Harnett County
420 McKinney Pkwy
LILLINGTON, NC 27546
Phone:
Fax:

12/12/2023

SUBJECT: SFD2309-0002
SINGLE FAMILY DWELLING

Here are the results of all Inspections located at **56 GREAT SMOKY PL:**

Job 23-5989-R01	Truss R08RP1	Truss Type Piggyback Base	Qty 5	Ply 1	LOT 0.0101 BLAKE POND   56 GREAT SMOKEY WAY LILLINGTON, NC
--------------------	-----------------	------------------------------	----------	----------	--

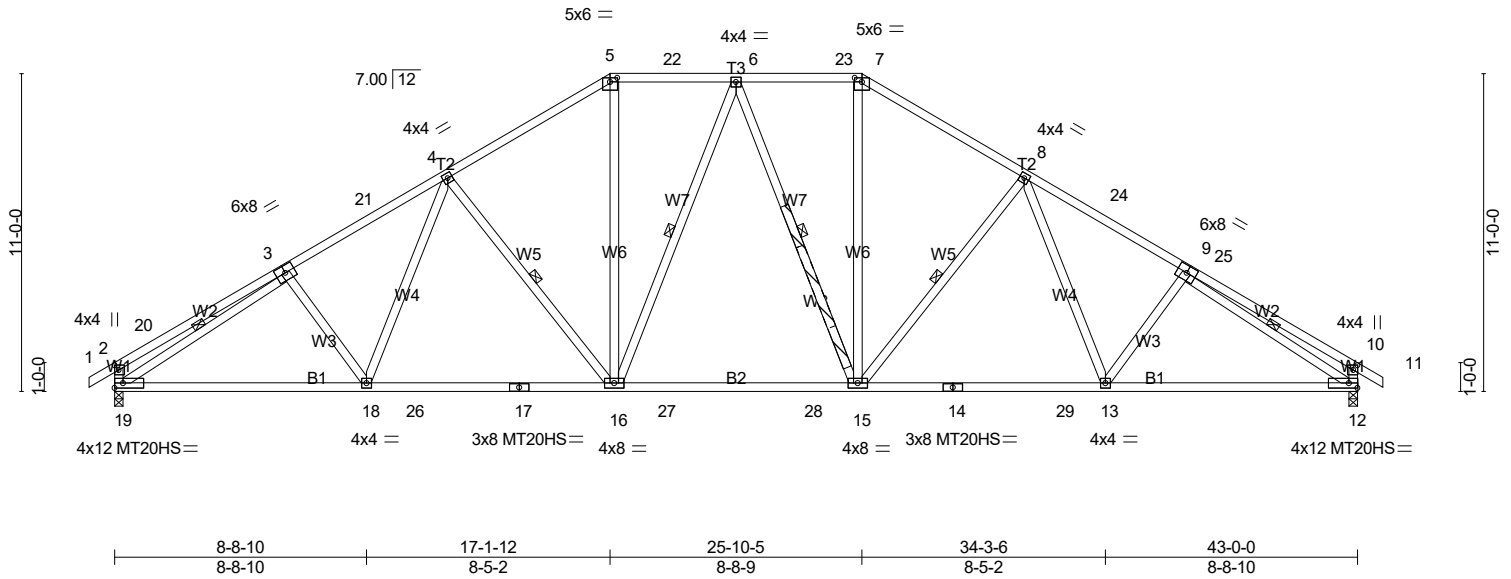
1. Need a stud at down stairs shower on garage wall studs need to be 16 oc on a load bearing wall 2. Outlet in low voltage panel needs to be secured 3. Porch post not installed 4. Missing nails in rear porch post 5. Missing blocking at stairs 6. Electrical wire just stapled to the floor at the top of the stairs 7. No stair wall or rail permanently installed 8. Seal hole in chase in the master suite 9. Drain test low 10. Missing nail plate on vent line at the bathroom at the top of the stairs and bathroom fan has parts on the floor 11. Missing a king stud between the double window in the front right bedroom upstairs also missing a king stud on the double window at the back of the house 12. R10 missing truss bracing 13. Seal holes in top plate in dining room by 3 inch drain 14. 2 R08 truss broken
